**Application no: 23/03139/REM**

**Location:** Land Adjoining Withycombe Farmhouse, Stratford Road, Drayton

### **Recommendation:**

Oxfordshire County Council, as the Local Highway Authority, **object** to the approval of this Reserved Matters application.

DRAKE

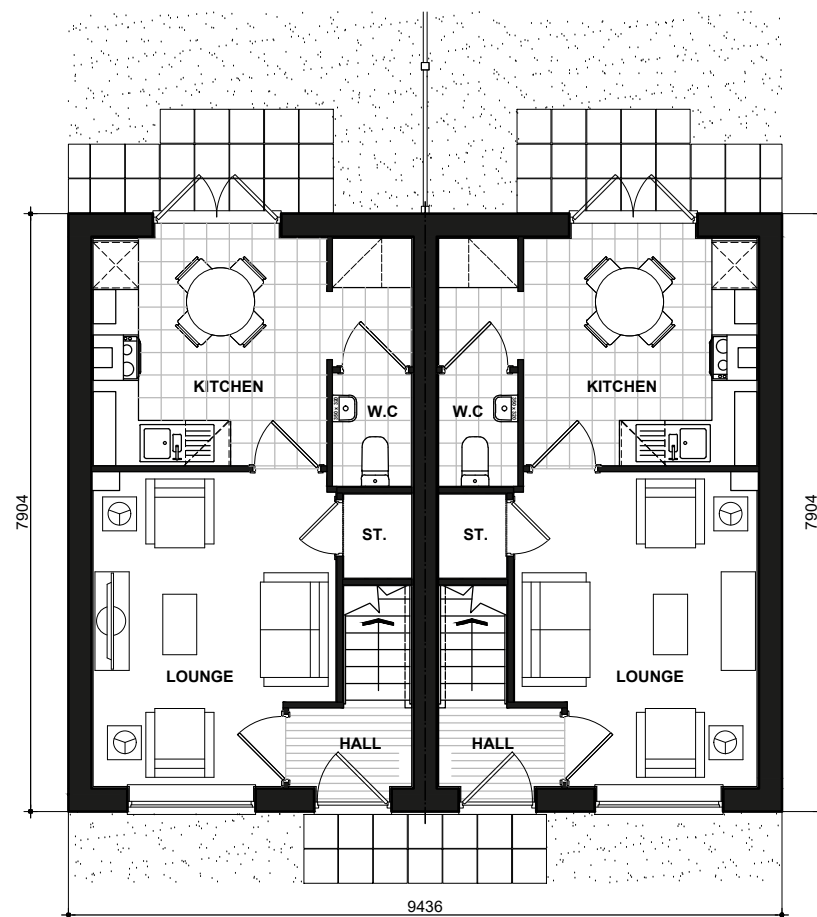
Dwelling types: Drake, Oahstone, Tiverton, Sansom, Elyot are all 2-bed houses and are currently allocated 2 vehicle spaces per dwelling, exceeding the standards listed above. The parking allocation must therefore be amended to reflect guidance.
